General considerations

The site under consideration for this development is the last remaining vestige of an iconic green belt space at the edge of Kidlington. It forms part an area of land purchased by OCC nearly 100 years ago to specifically prevent the coalescence of Kidlington with the city of Oxford. It also represents perhaps the last vestige of untouched wild space in the area and is part of the iconic Kidlington Gap. As local authorities, both OCC and CDC have a duty to defend those areas held in trust for the local community. Any development on this site would also contravene CDC planning policy and a local plan that has only recently been updated.

Proposed concrete block paving | Proposed cycle parking with boulevard tree planting | Combined footpath & cycleway | Oxford Road

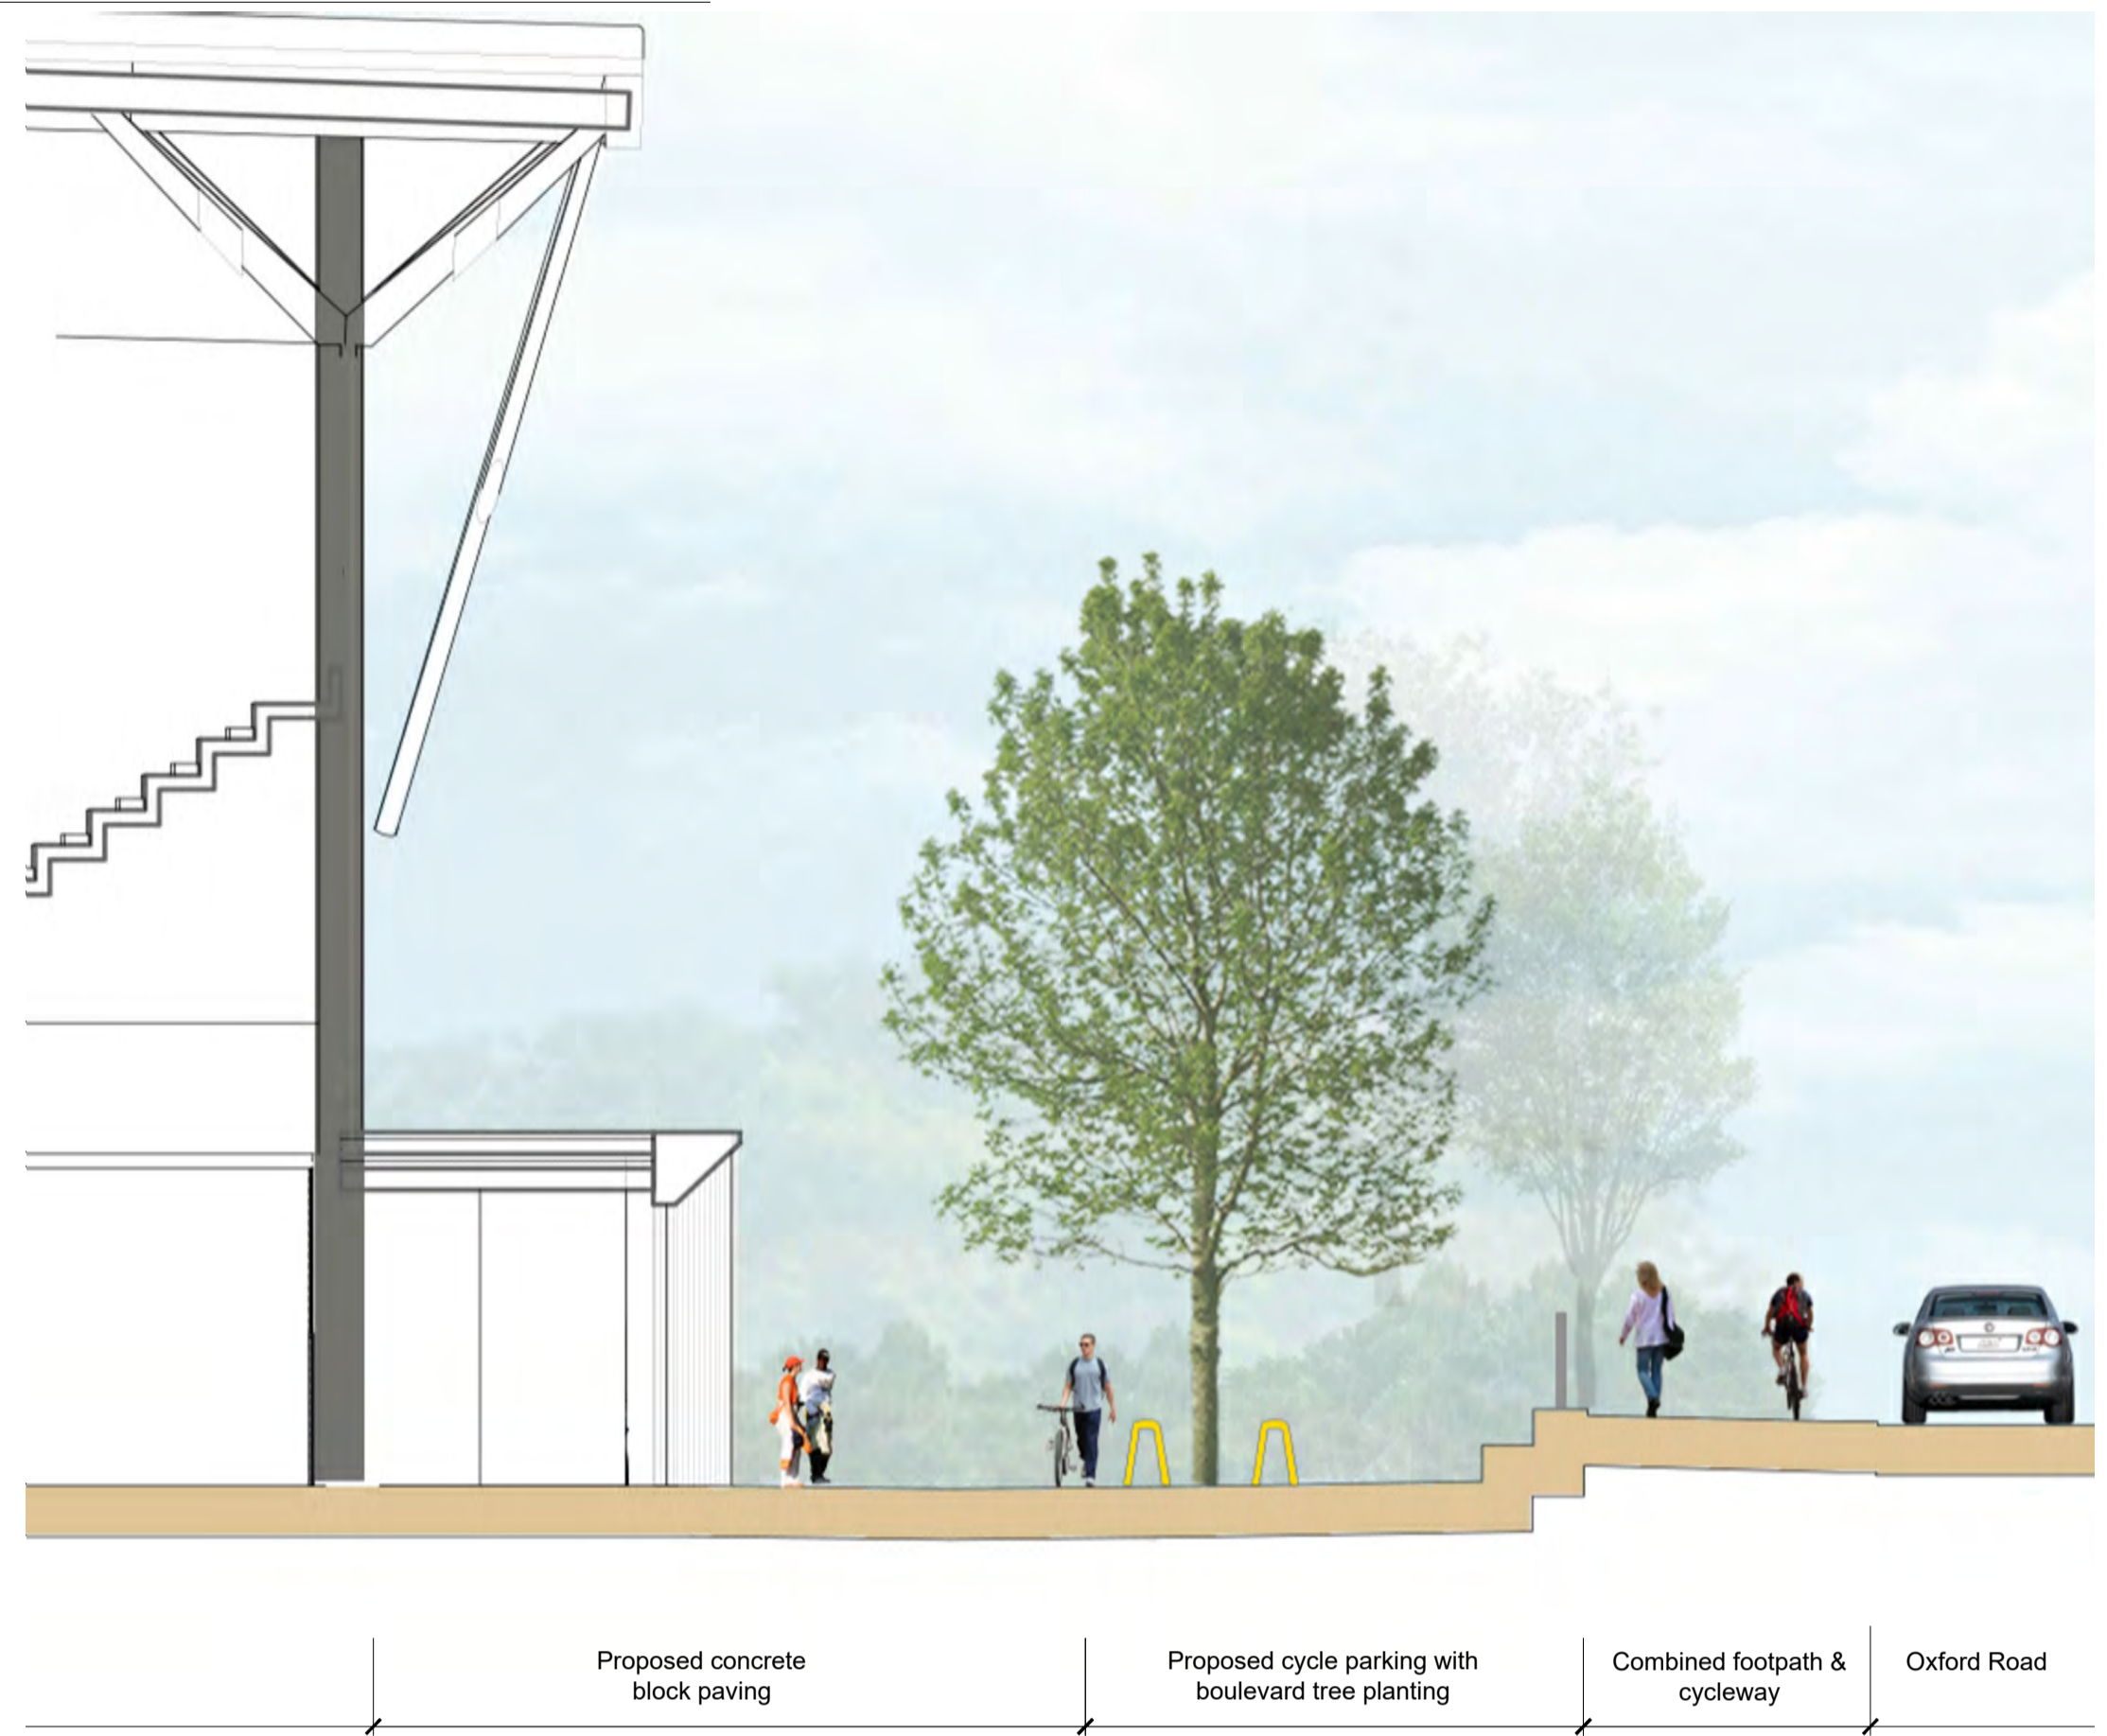
Drawings contained within the application show the permanent deletion of the bus lane currently running along the east side of Oxford Road. This is contrary to the local transport policy as it will not allow buses to bypass slow traffic during the morning rush. This will significantly increase the journey time to Oxford.

This presents a number of problems in highways terms, not least the loss of a facility that has been in place for a number of years and is still an integral part the road and traffic strategy for the area. Indeed it is further facilitated as part of the current Kidlington roundabout works which include additional clearways for buses to exit the Bicester Link Road on to the Oxford Road.

The provision of the bus lane was specifically intended to reduce congestion on this road a main route into Oxford City. Its removal will again have significant impacts on traffic flows in the area, especially during rush hours. It also raises safety concerns for cyclists if we have buses being pushed out of the bus lane into the main carriageway and the back again. As we have already had a cyclist fatality on this stretch of road due to conflicts with HGVs this raises very serious concerns for their safety.
